Please ask for: Ms Iqraa Malik  
Email: [iqraa.malik@terraquest.co.uk](mailto:iqraa.malik@terraquest.co.uk)  
Telephone: 01212341390  
Our Ref: BR/189/21/HH  
Your Ref:  
Date: 22nd July 2021

**Application for Planning Permission for Works or Extension to a Dwelling**

**Development:** resubmission of BR/63/21/HH  
**Location:** 2a Merchant Street Bognor Regis PO21 1QH

Proposed Rear Extension Plans and Elevations Planning
Date February 2021
Scale 1:200 1:1250

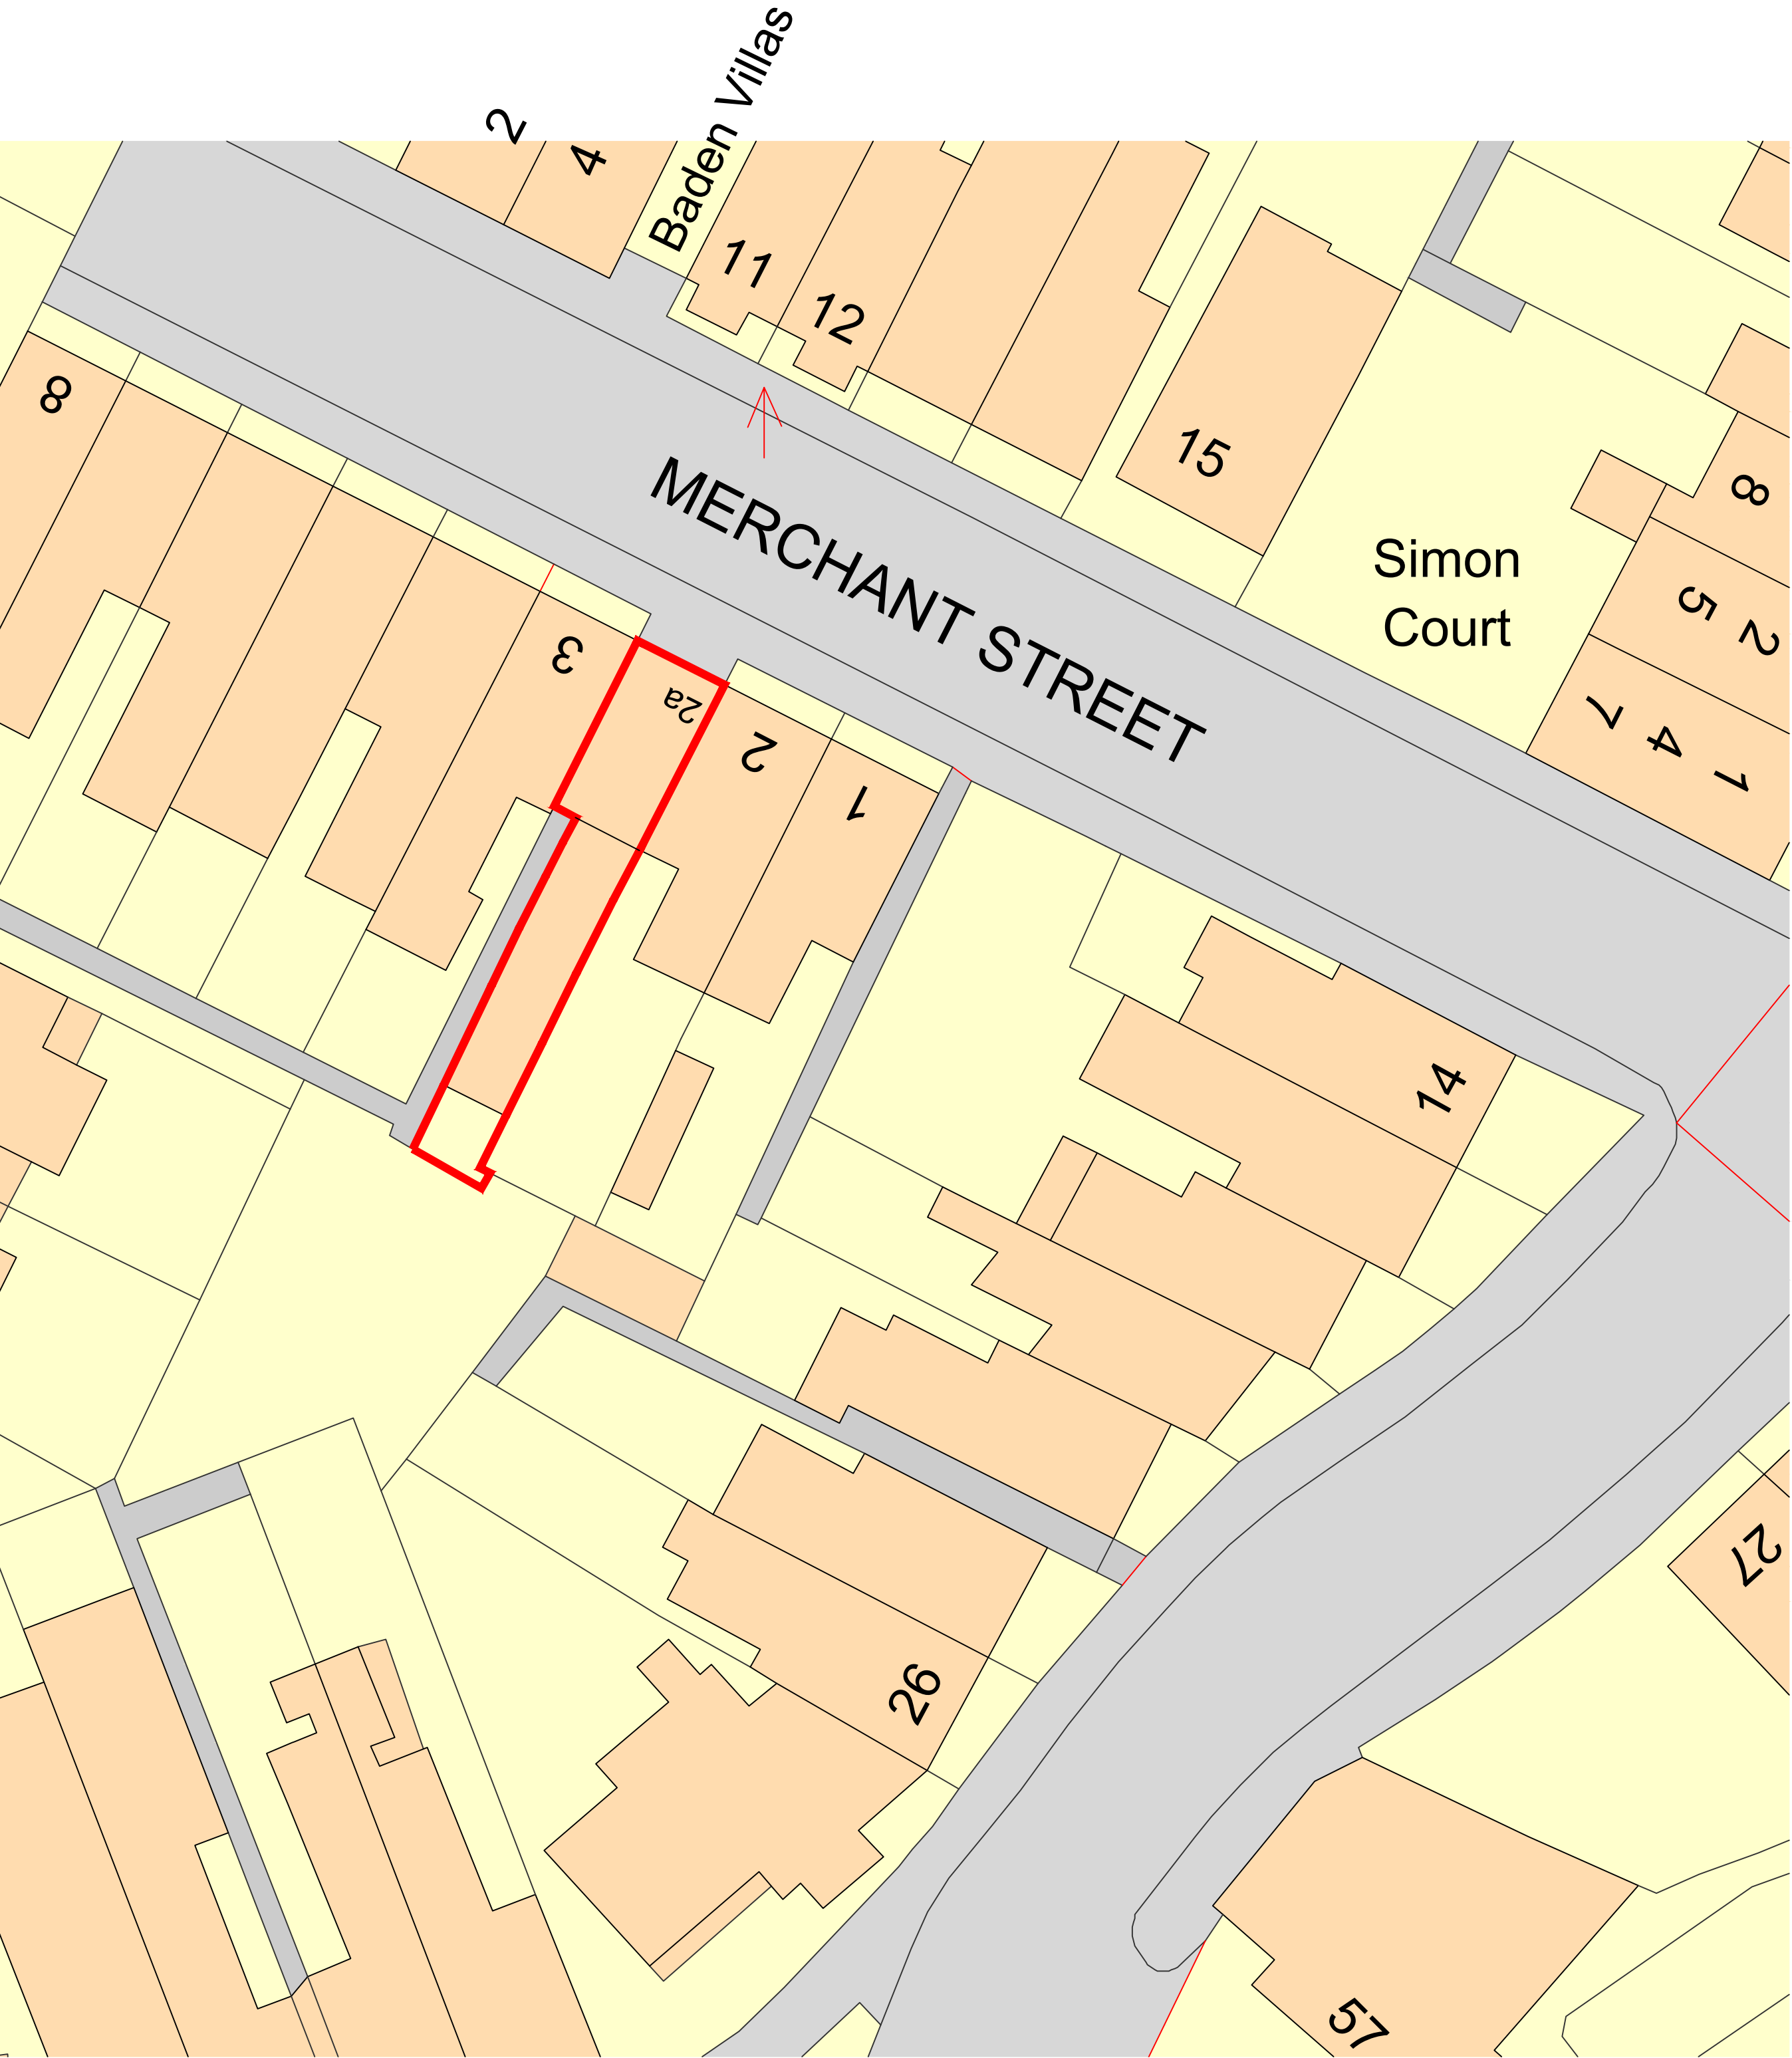
Block Plan

You are required to have dimensions from the proposed extension(s) to all site boundaries. Please amend.
